**Subject:** Rezoning Petition Review

**Rezoning Petition #:** 22-096

**Proposed Zoning:** MUDD-O

**Location of Property:** Approximately 34.73 acres located along the west side of John Adams Rd, south of Galloway Rd, north of W Mallard Creek Church Rd and east of I-85.

REZONING SITE PLAN

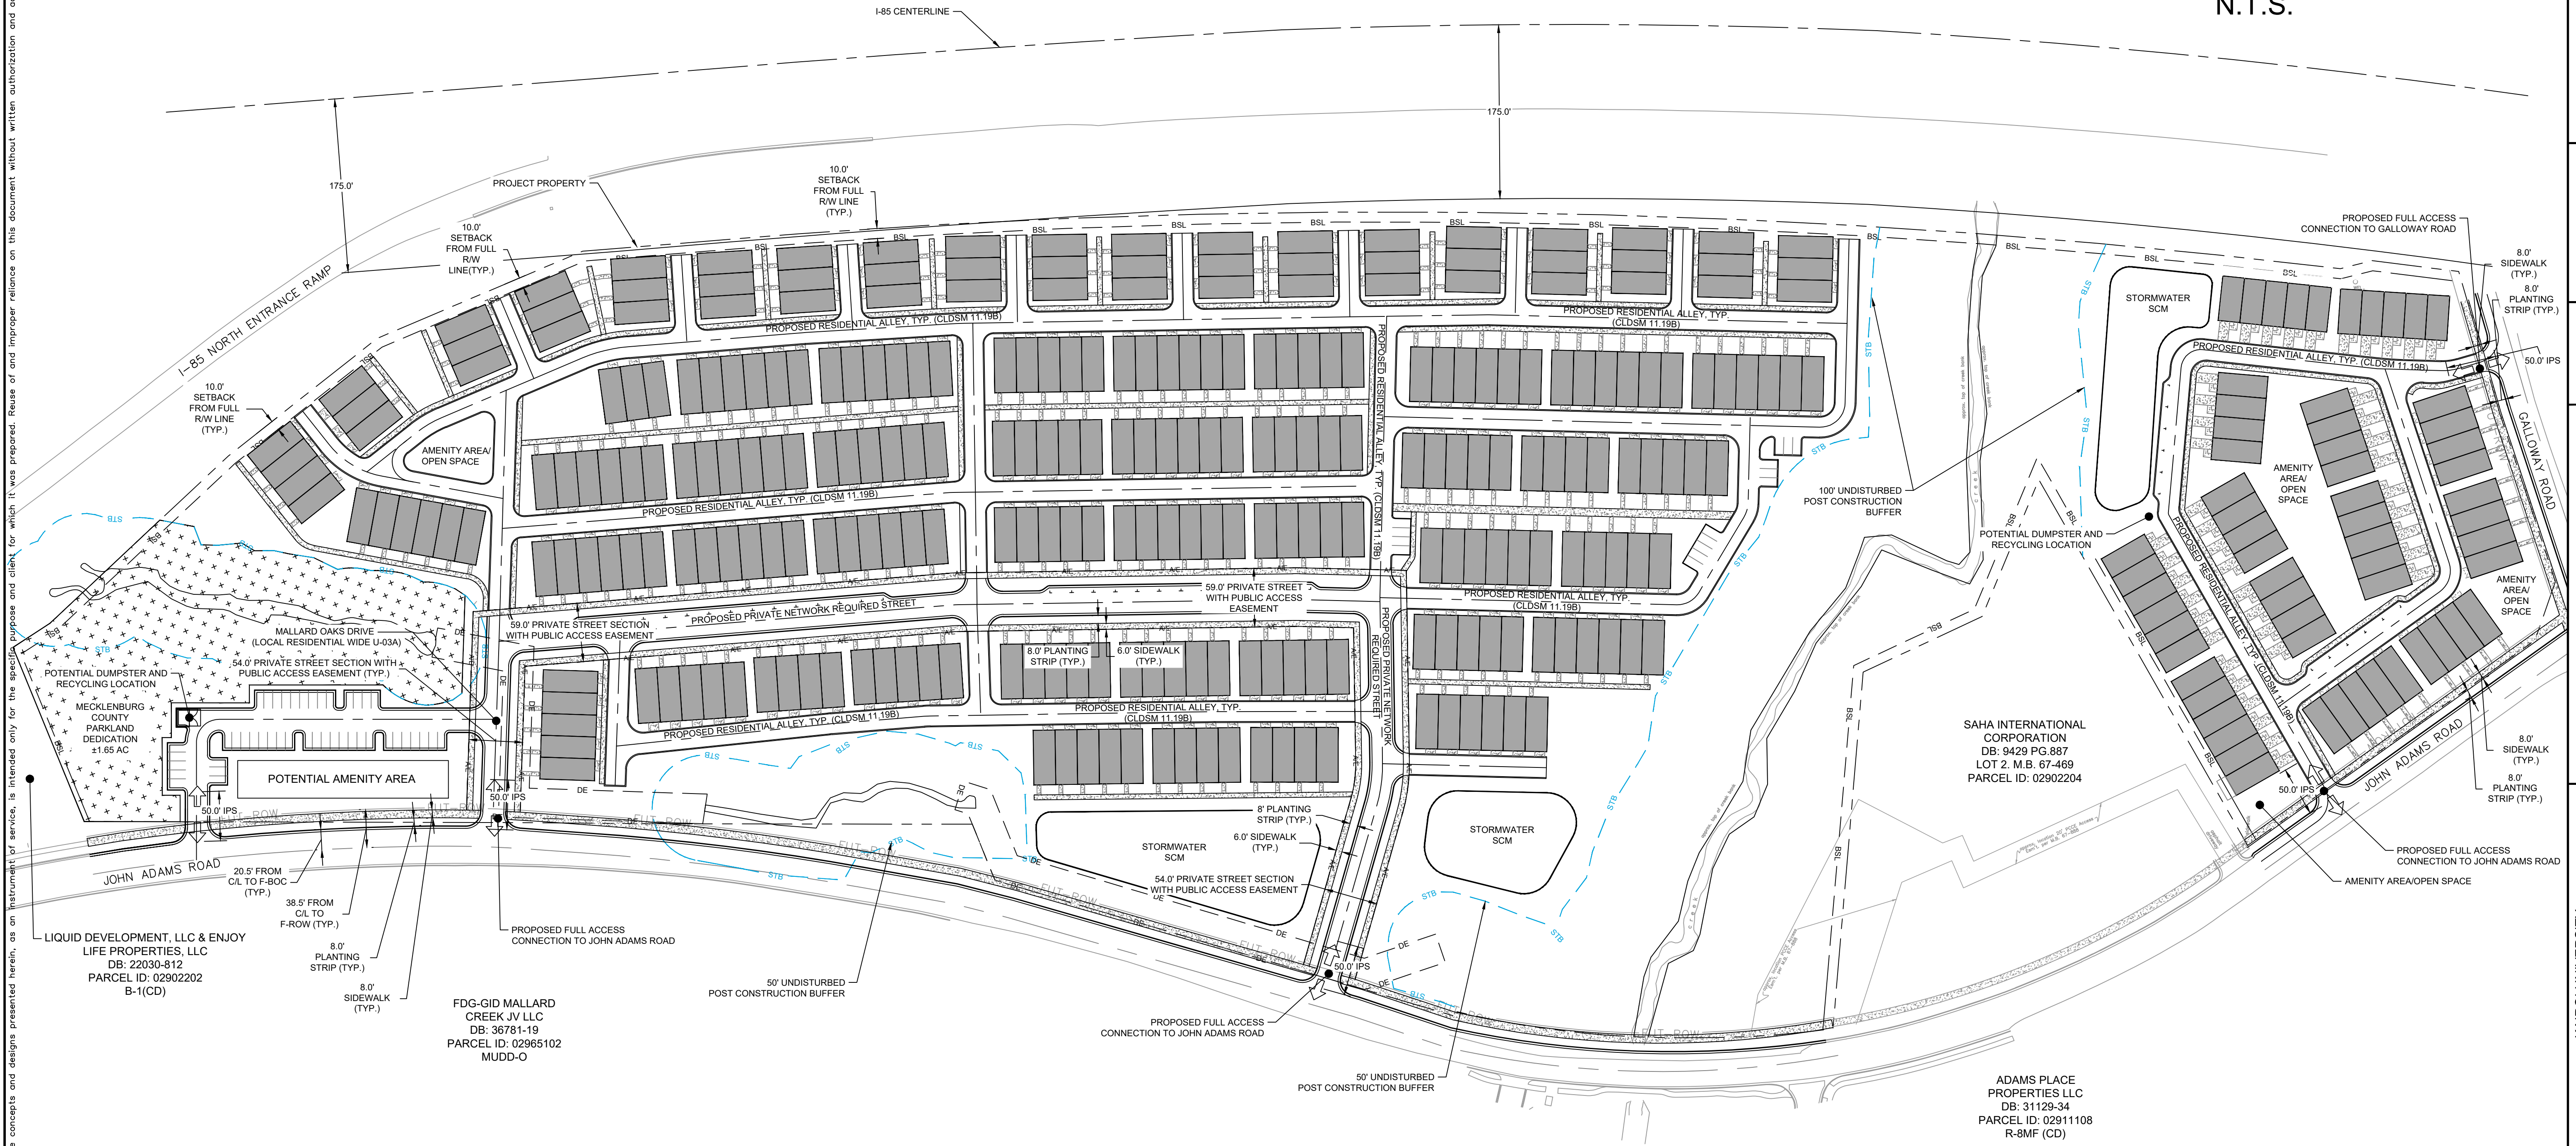
The proposed rezoning plan sheet indicates a proposed location for storm water management. Please include the following notes on the plan sheet under "Environmental Features": *The location, size, and type of storm water management systems depicted on the Rezoning Plan are subject to review and approval as part of the full development plan submittal and are not implicitly approved with this rezoning. Adjustments may be necessary in order to accommodate actual storm water treatment requirements and natural site discharge points.*

Any increase of impervious area within SWIM/PCSO buffers may not be allowed and is not approved with the rezoning process. Please include the following note under Environmental Features: *"Development within any SWIM/PCSO Buffer shall be coordinated with and subject to approval by Charlotte-Mecklenburg Storm Water Services and mitigated if required by City ordinance. Petitioner acknowledges intermittent/perennial stream delineation reports are subject to review and approval upon submission of development plans for permitting and are not approved with rezoning decisions."*
